KITTITAS COUNTY COMMUNITY DEVELOPMENT SERVICES

RE: Shoreline Exemption - SX-24-00022– Deemed Incomplete

PARCEL R  
SEC. 1, T. 18 N., R. 17 E., W.M.

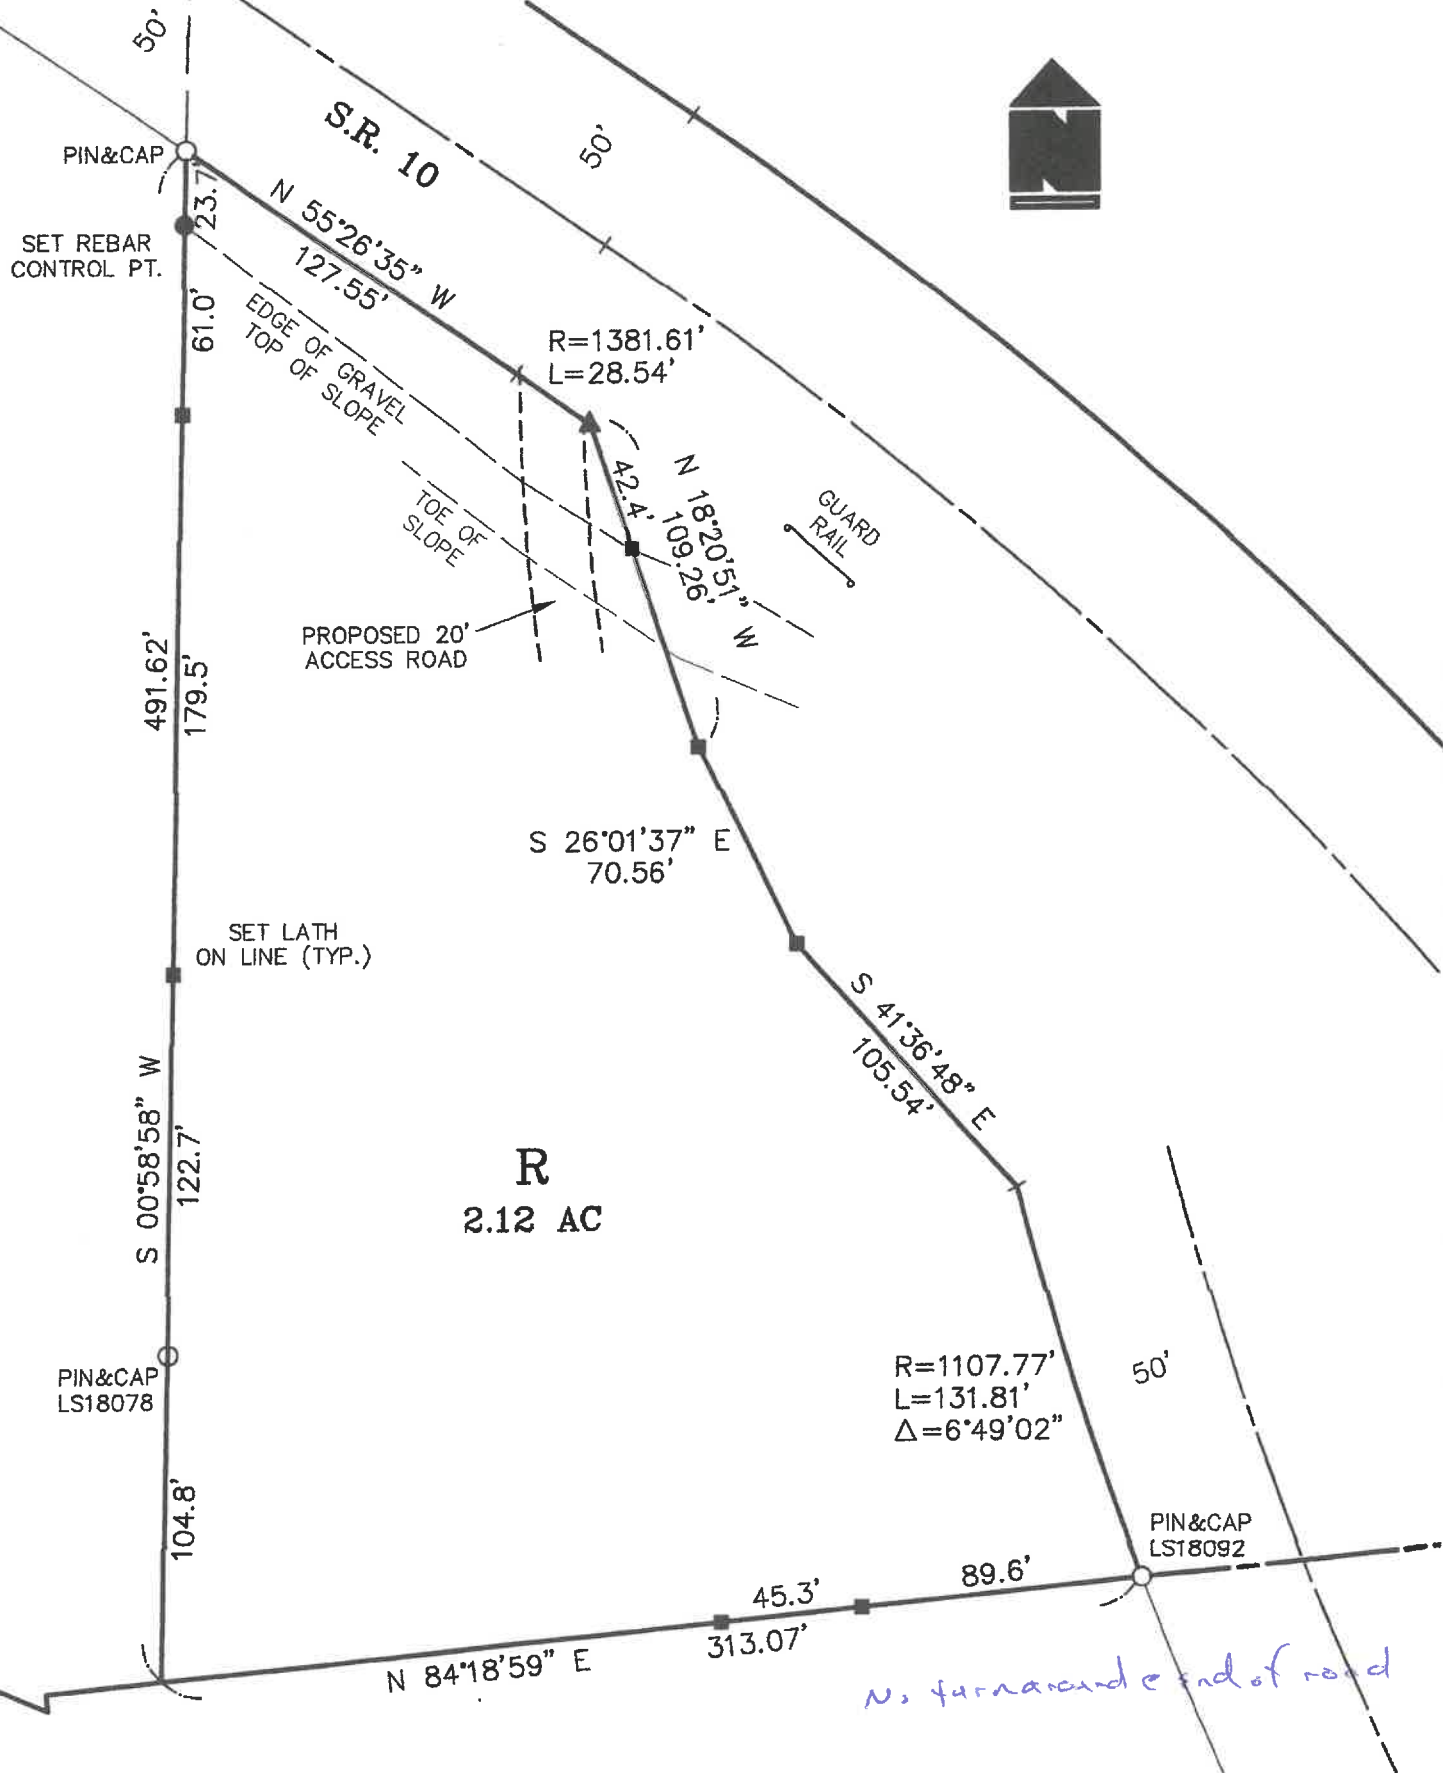
1. Updated site plan showing the dimensions & location of the proposed driveway to include starting point, full driveway, ending point, length, width, distance from Ordinary High-Water Mark, distance from edge of Floodway to the driveway, and distance from each lot line to the edge of the driveway.
